## HINCKLEY RAIL FREIGHT TERMINAL

Comments for Deadline 6

CPRE Leicestershire

February 2024

Figure 5-4: Cycle Route Enhancements

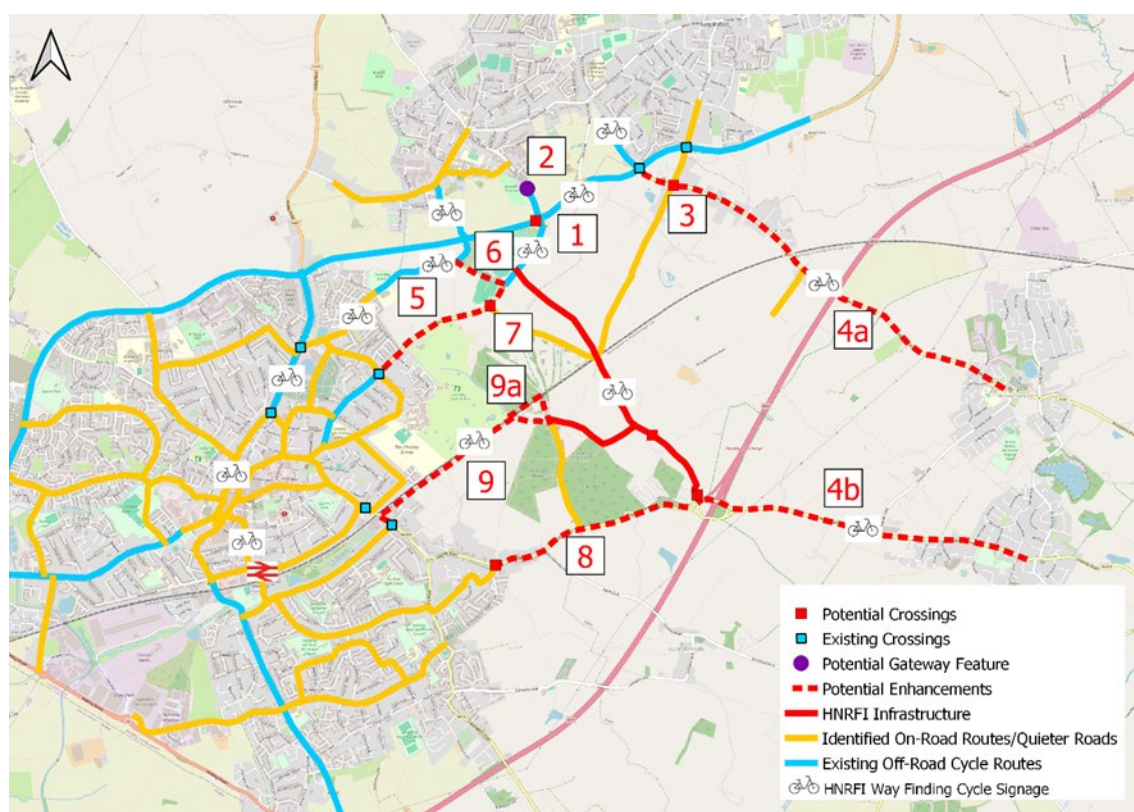
3.3 This is echoed in the new Para 8.1 of the Travel Plan:

3.4 A number of options have been identified and the STRAVA data (as previously discussed) supports those but the new options are limited, especially in relation to the Eastern villages. What the text still does not acknowledge is the disincentive to cycle on routes where there are significant traffic increases.

3.5 Both paragraphs refer to these ‘*additional enhancements*’ but not increased actual cycling.

3.6 We consider the result of these proposals will be a significant disincentive to cycle on more-congested routes.
